CITY OF PORTLAND, MAINE

September 30, 2016

Project Name: Amendment to July 2016 approval
“Station 415” Subdivision and Change of Use/Renovation of Building:
Co-Working Office Unit and four (4) Apartments
Project ID: #2016-196
Address: 415 Cumberland Avenue CBL: 036 G033001
Applicant: Andrew Kraus, M & A Lowcountry Investments, LLC
Planner: Jean Fraser

FOREST AVENUE ELEVATION  
SCALE: 1/8" = 1'-0"

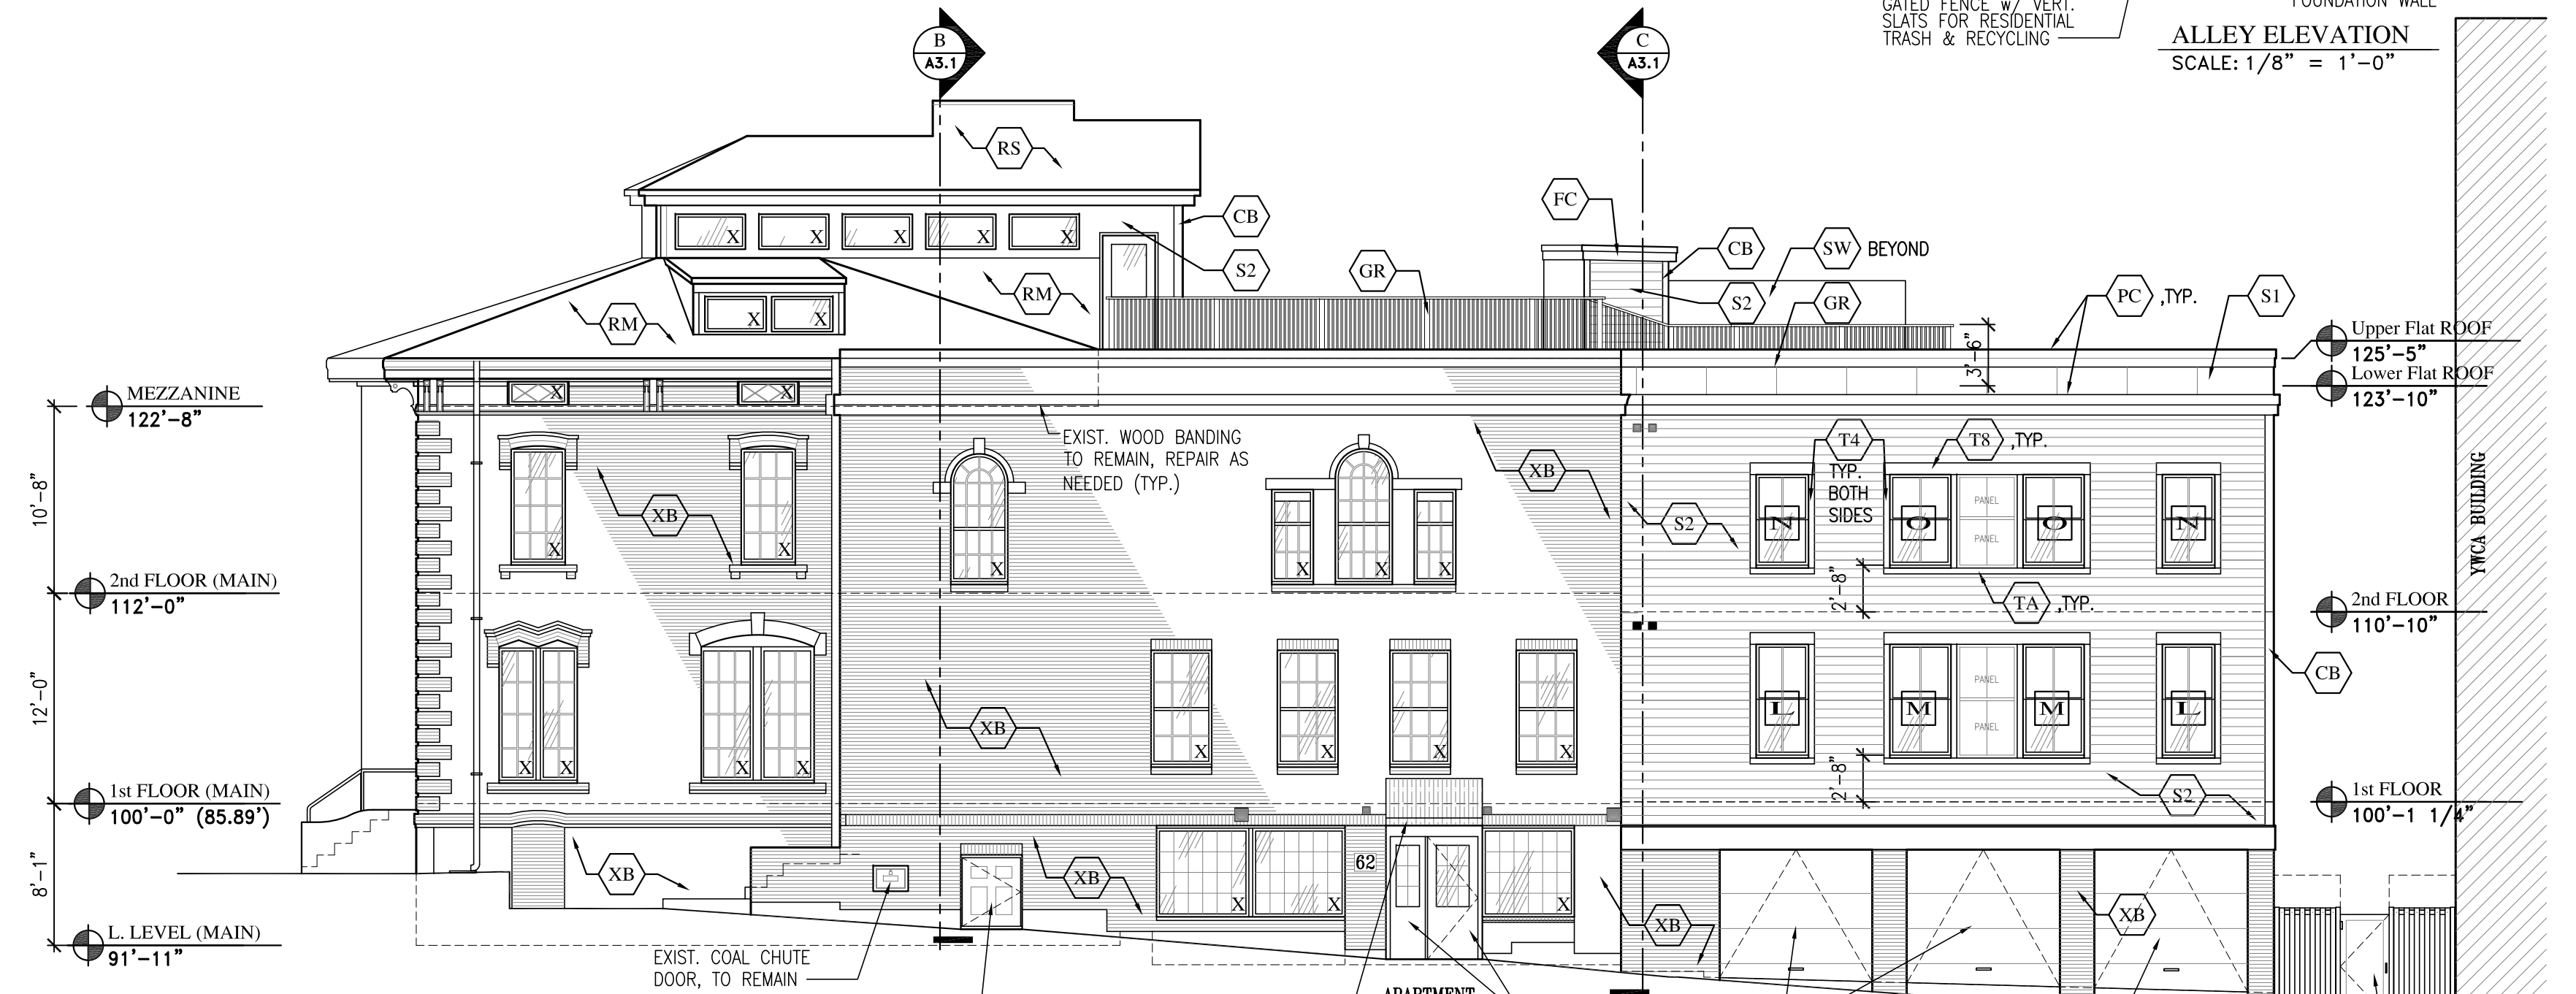
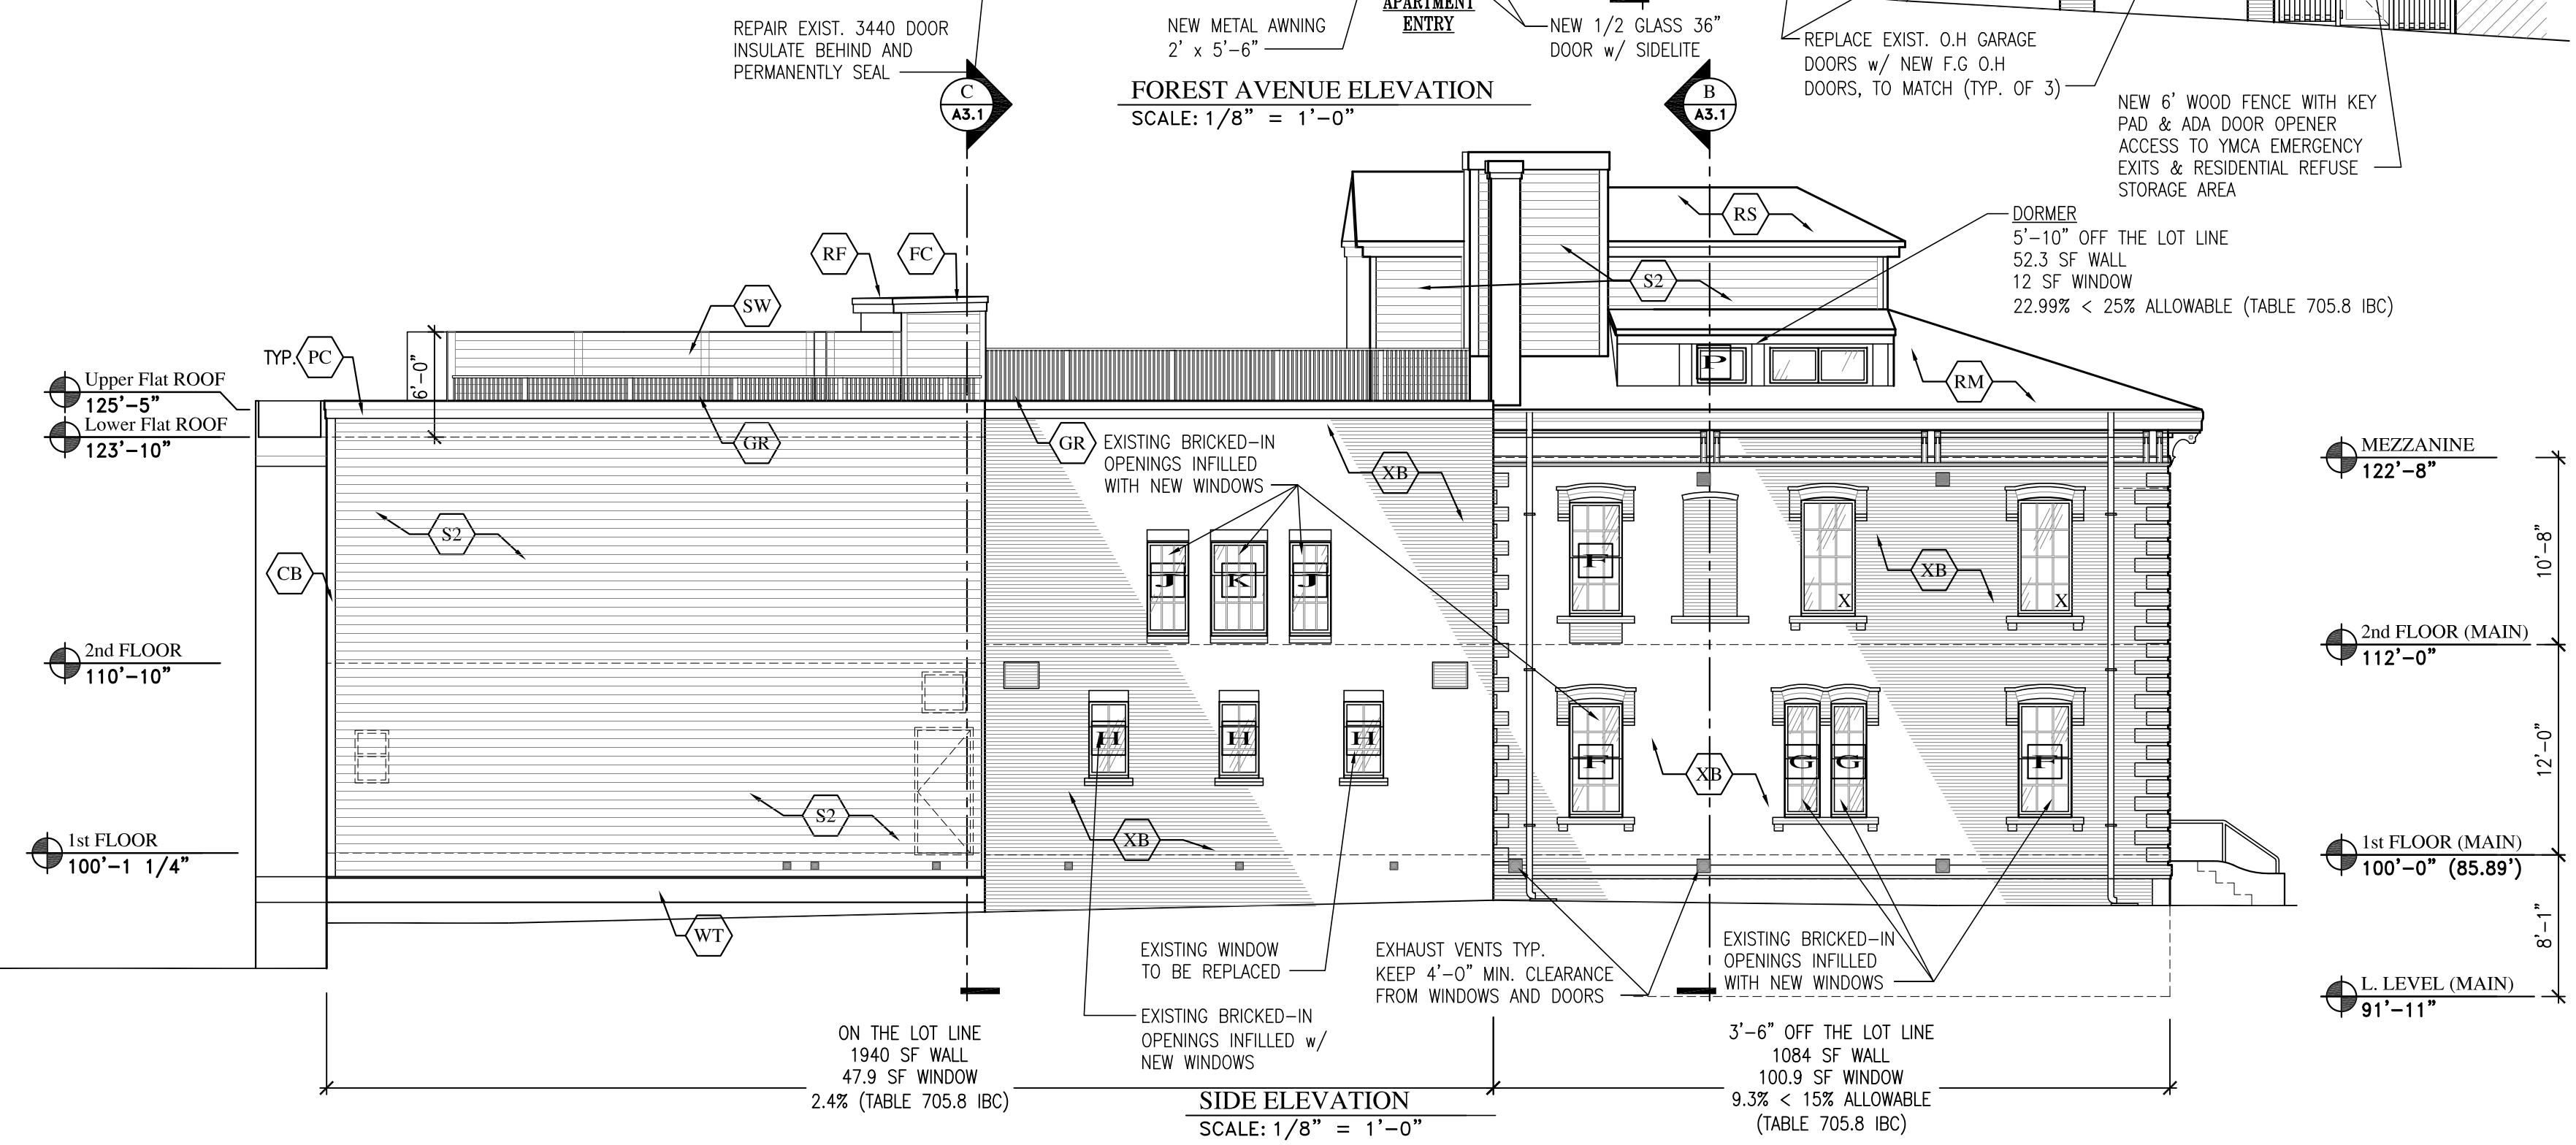
The applicant has revised the cladding since the July approval and discussed the amendment with the Historic Preservation Program Manager, Deb Andrews. A comparison between the approved and amended cladding is set out below:

The previously approved cladding was 48" X32" "Hardie" reveal panel system with aluminum trim over "Tyvar" building wrap, with aluminum fry reglets:

The current amended proposals (below) were revised to because of the high cost of the original specification. The proposed cladding is now 6" TTW "Hardie Plank" lap siding over "Tyvar" building wrap (color TBD) and illustrated below:

The Historic Preservation Program Manager, Deb Andrews, welcomes the removal of the brown wood cladding and has reviewed the amended proposals. She has confirmed that the final proposals are generally compatible with the historic structure/district (Attachment 5).

ARCHITECTURAL  
 SITE  
 PLAN  
**AS1.1**

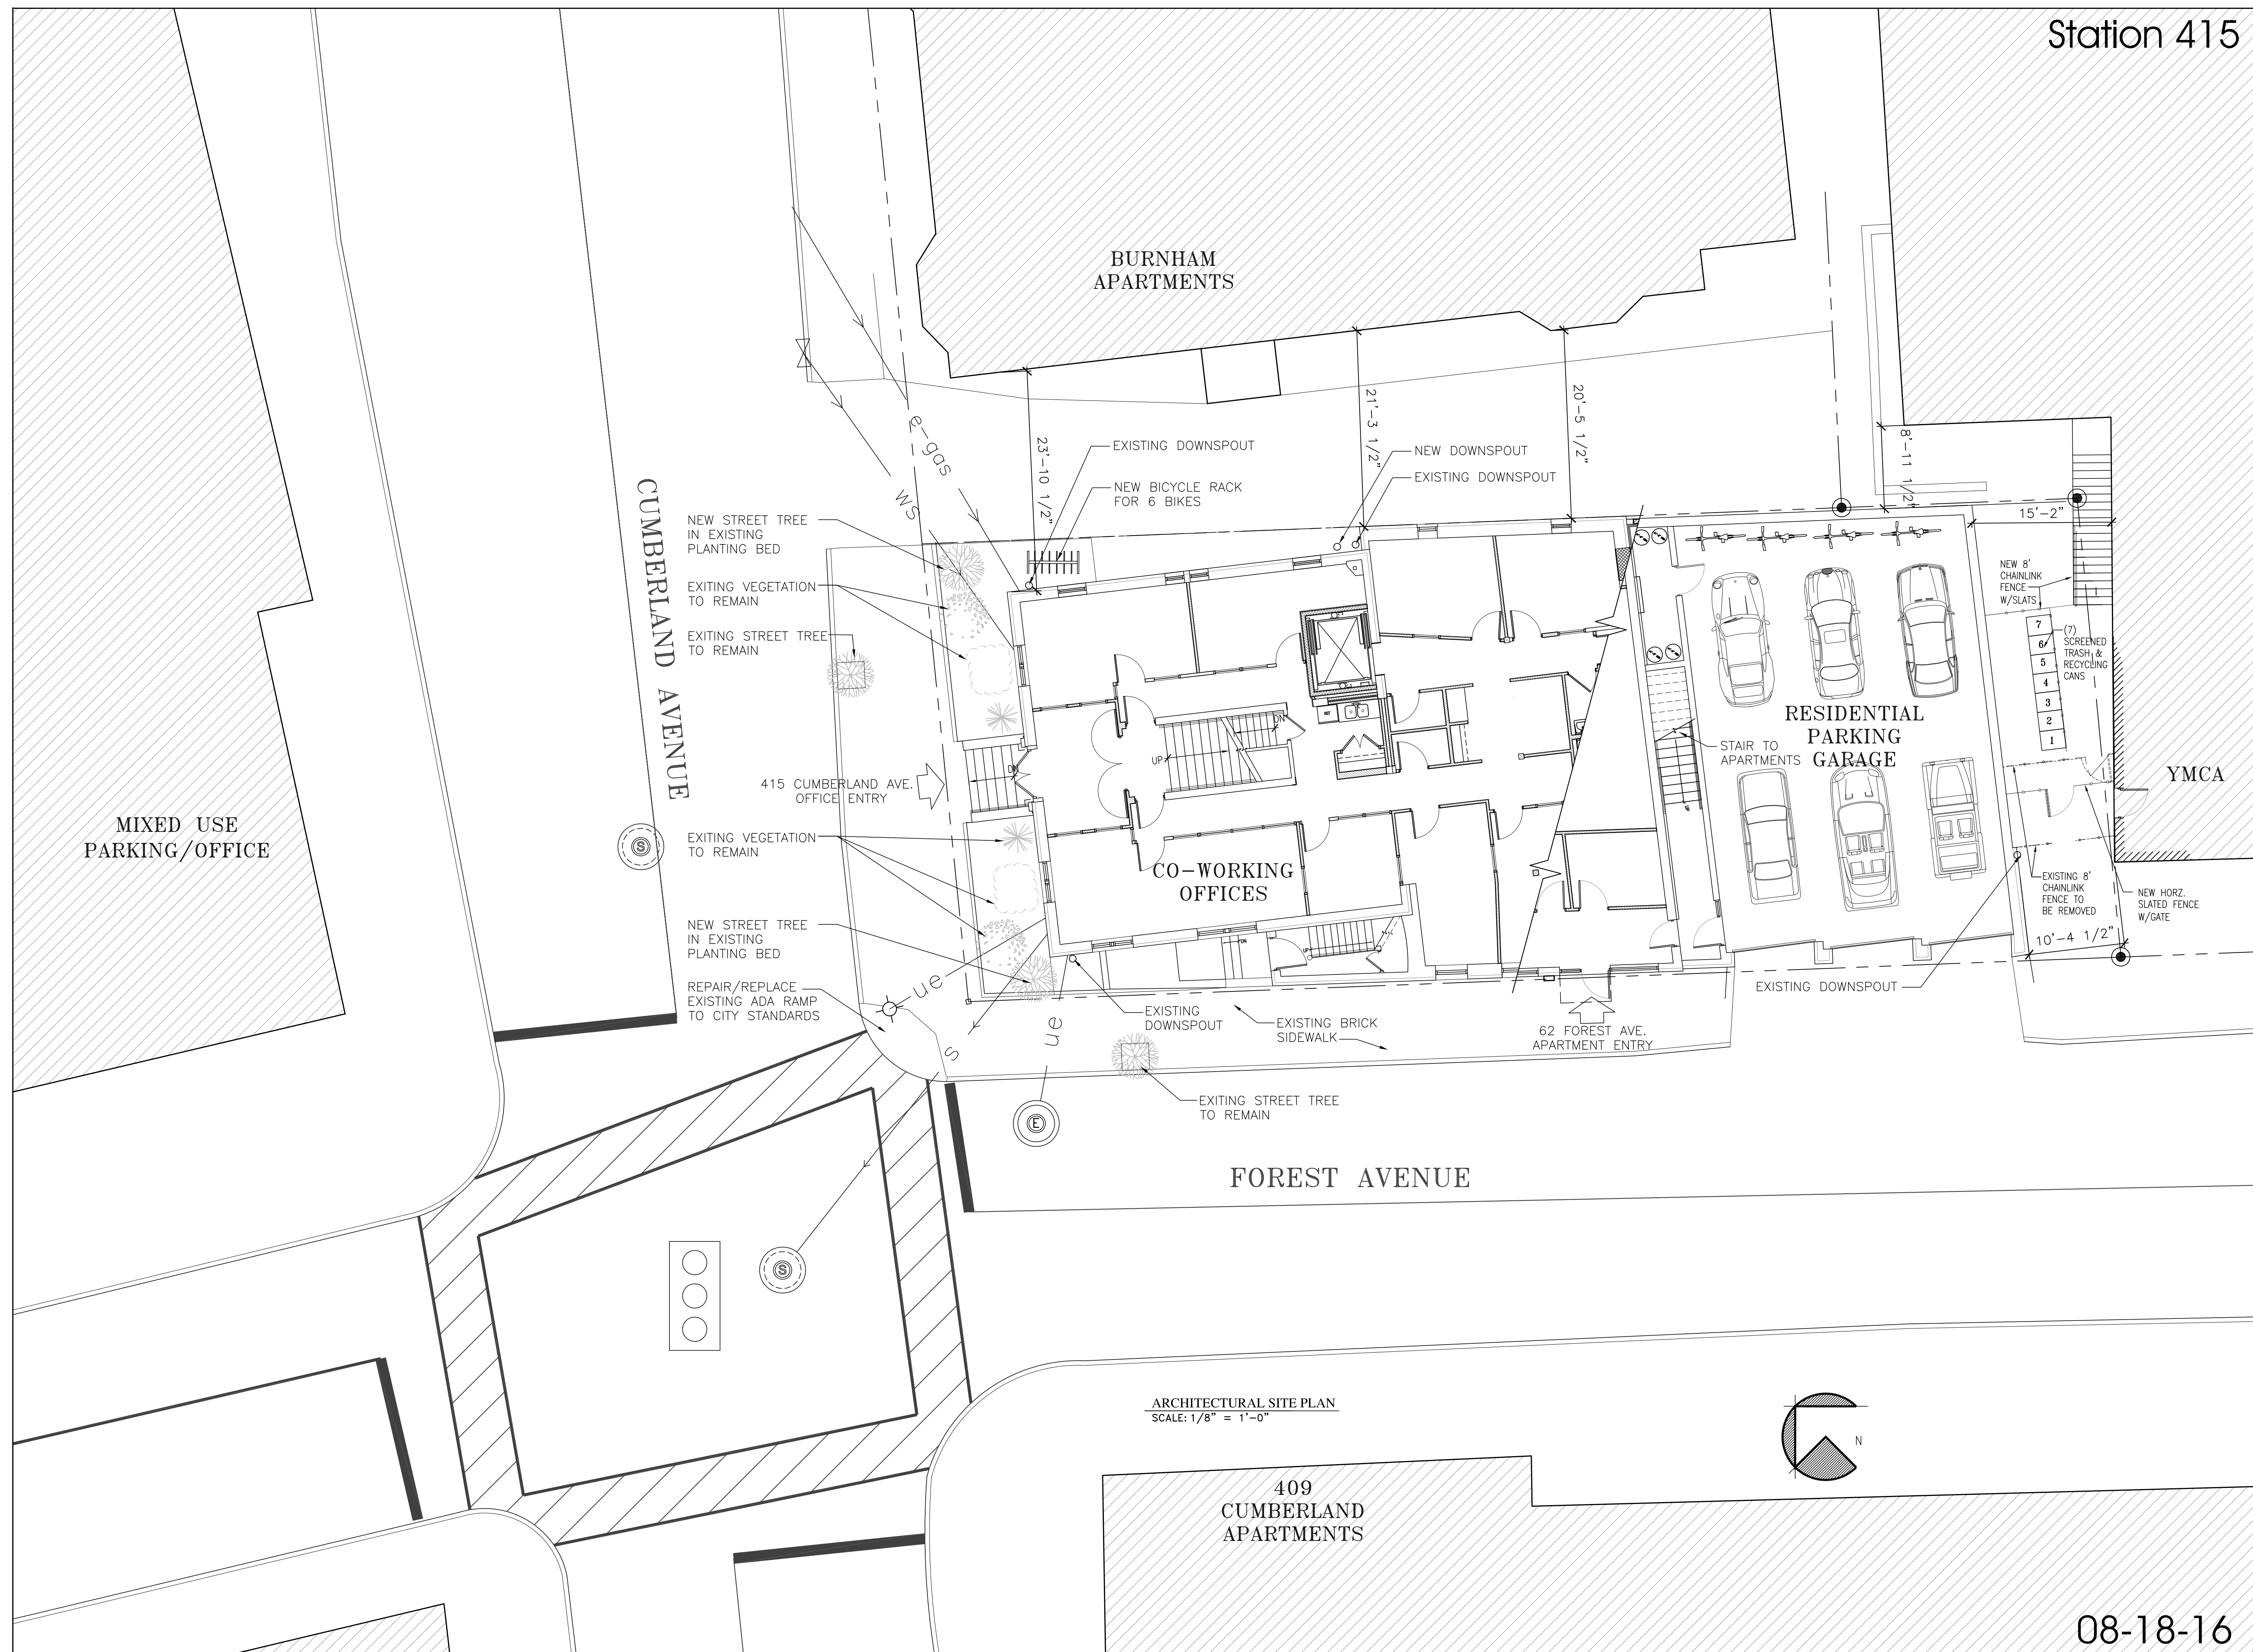
- a. The repair/replacement of the ADA ramp panel in the ROW at the corner of Forest Avenue and Cumberland Avenue;
 - b. The route to the outside bike racks located within the applicant's property; and

- c. Details/specifications of the new fence along the back of the sidewalk near the trash storage area.
- ii. That the tandem parking spaces be designated for the residential units only (or for low turnover use) to ensure that backing maneuvers onto Forest Avenue are minimized given vehicle and pedestrian traffic levels; and
